From: Sue Howell <Sue.Howell@arun.gov.uk>
Sent: 18 December 2019 14:35
To: Planning.Responses <Planning.Responses@arun.gov.uk>
Cc: Anita Gardner <Anita.Gardner@arun.gov.uk>
Subject: RE: Planning Consultation on LU/295/19/DOC

Further to WSCC consultation comments and subsequent submission of revised drawings Detailed Planting Plan RCo 285/02 Rev 03, Soft Landscape Layout RCo 285/01 Rev 04 and detailed Plant Schedule and Specification 12/12/19 I can confirm that I have reviewed these amends as follows.

APPLICATION NO: LU/295/19/DOC

Site Address: Land At Toddington Farm North And West Of 1 To 3 Toddington
Toddington Lane Littlehampton BN17 7PN

Detailed Planting Plan

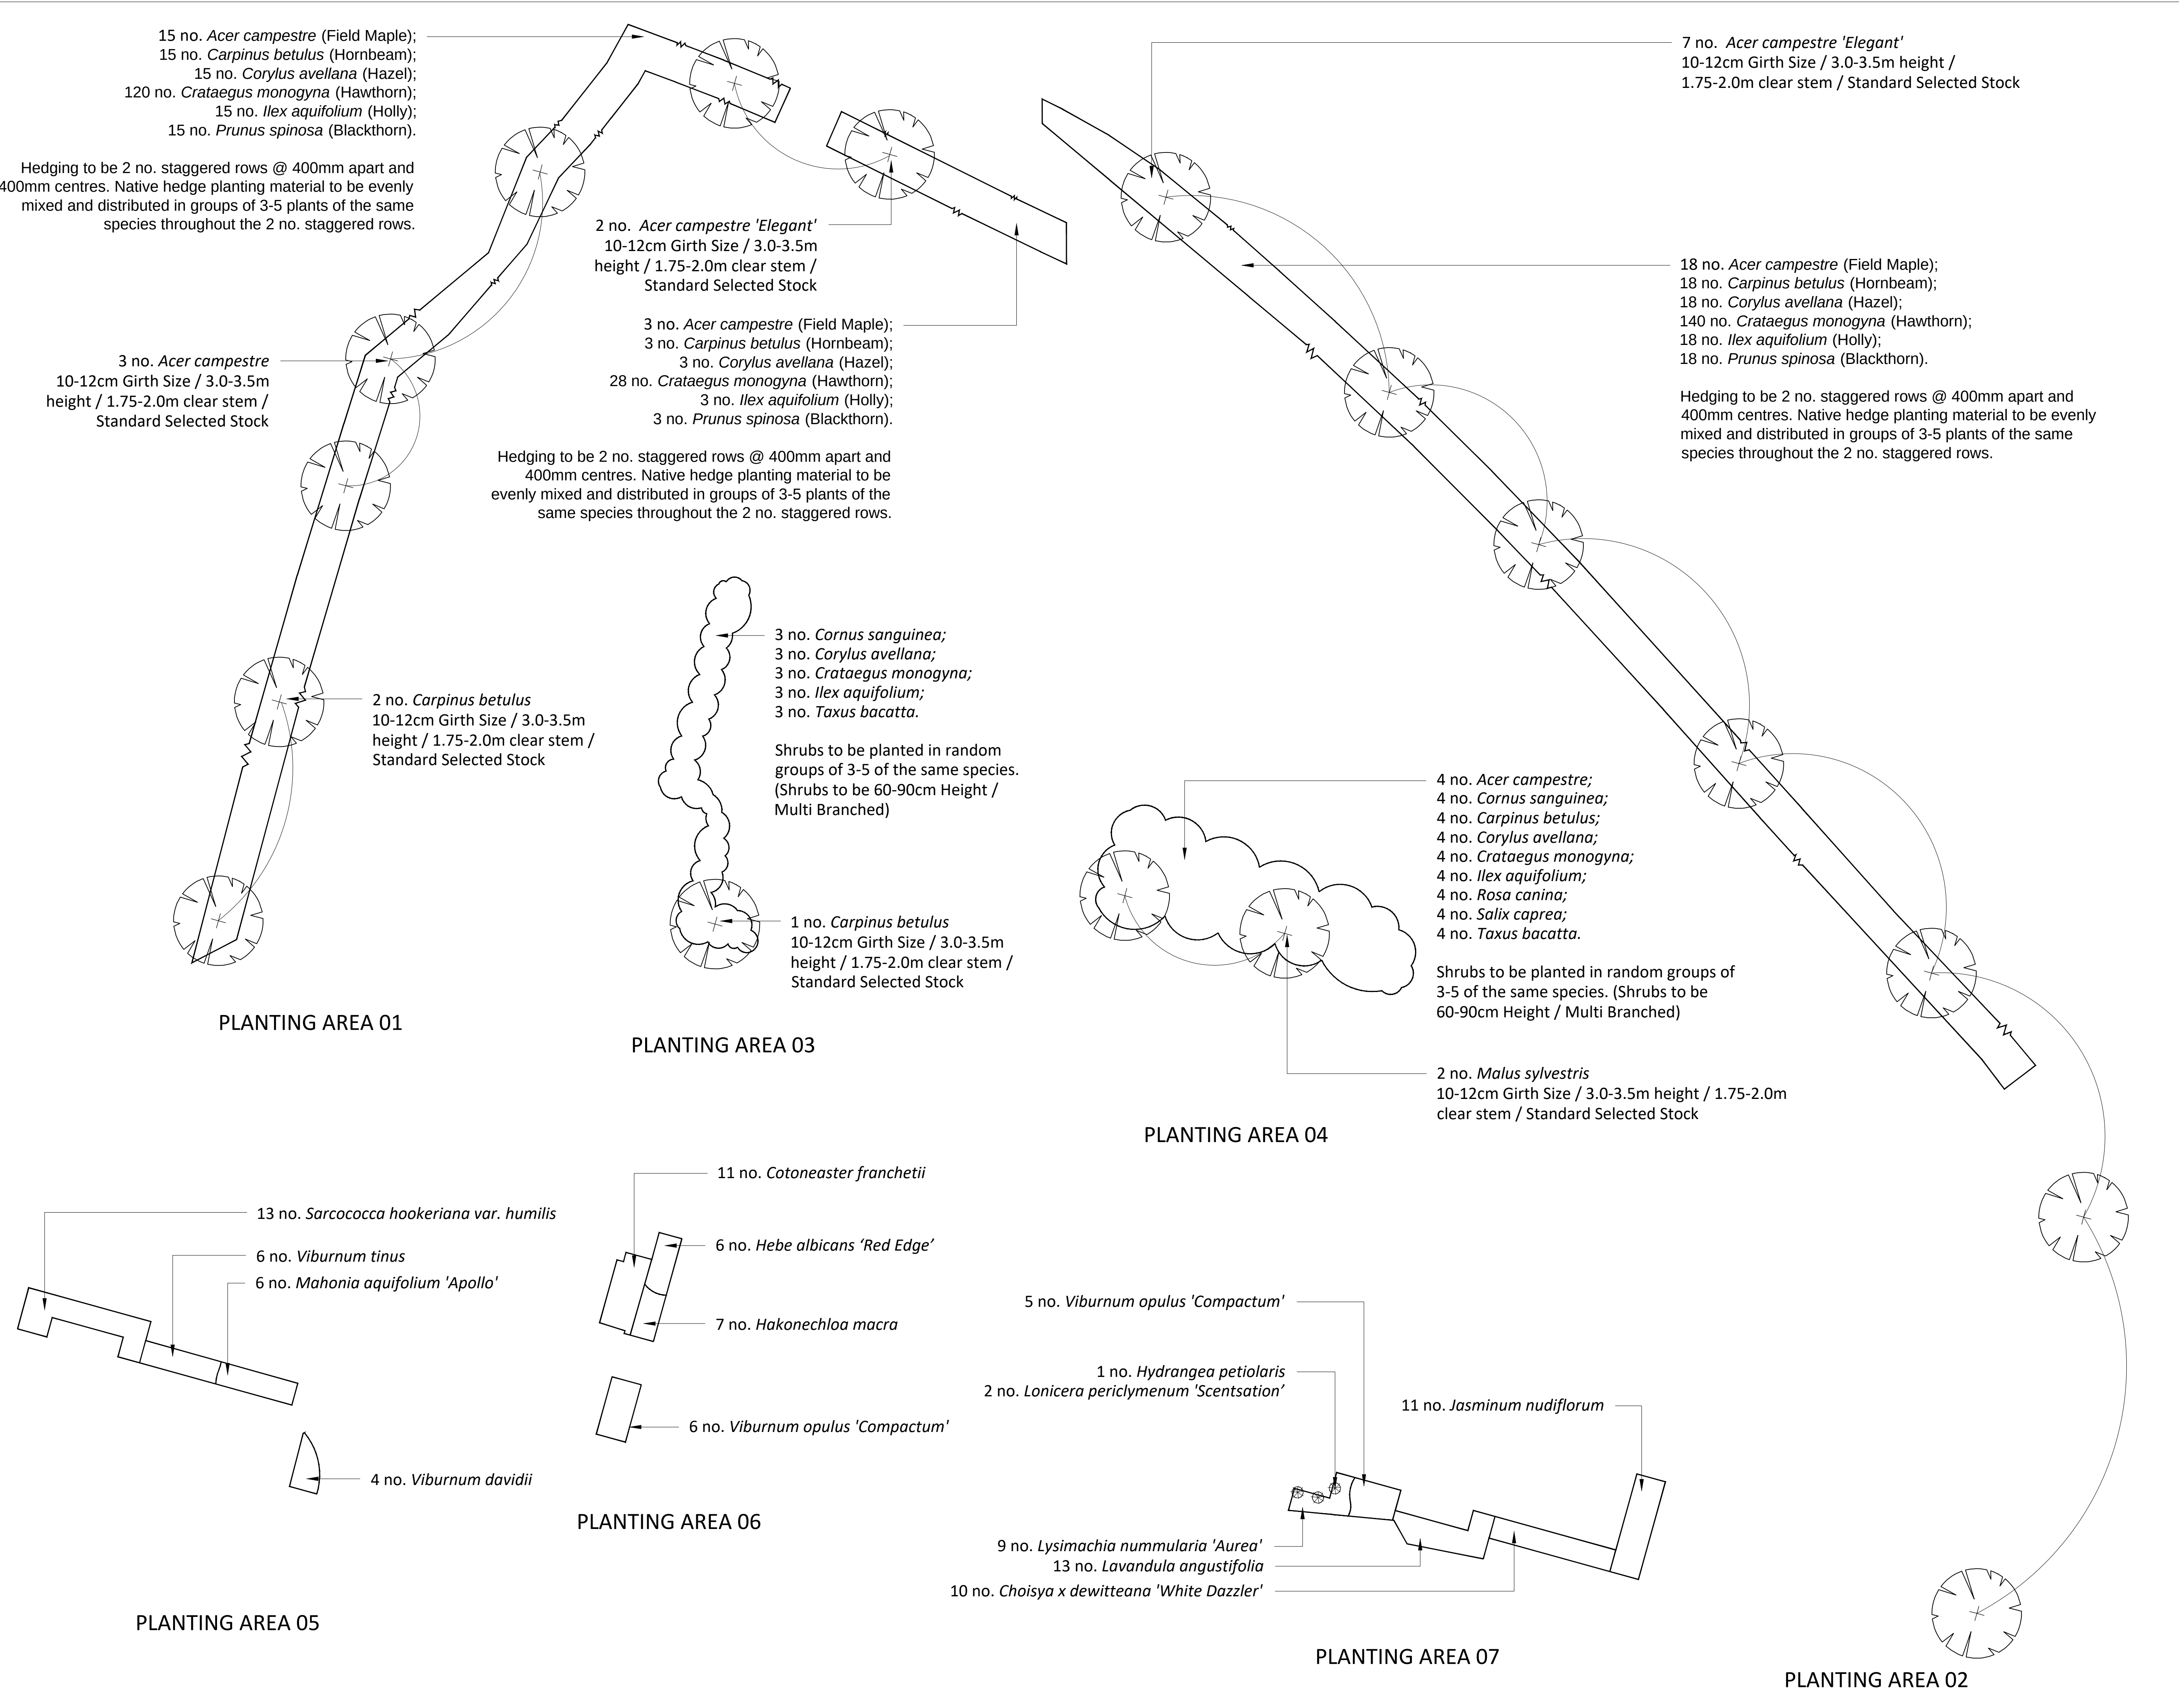
The information now submitted in plan form does propose a comprehensive scheme which is fitting and suitable for location, the scheme has been amended in line with WSCC sight line requirements to the road frontage areas 01 and 02. This amend has the most effect on Plot no's 8, 9 & 10 with now omitting planting to this frontage. I do not however see this to be an issue because of the level differences in this location and the result in sight line improvement to the crossing point can only be seen as beneficial.
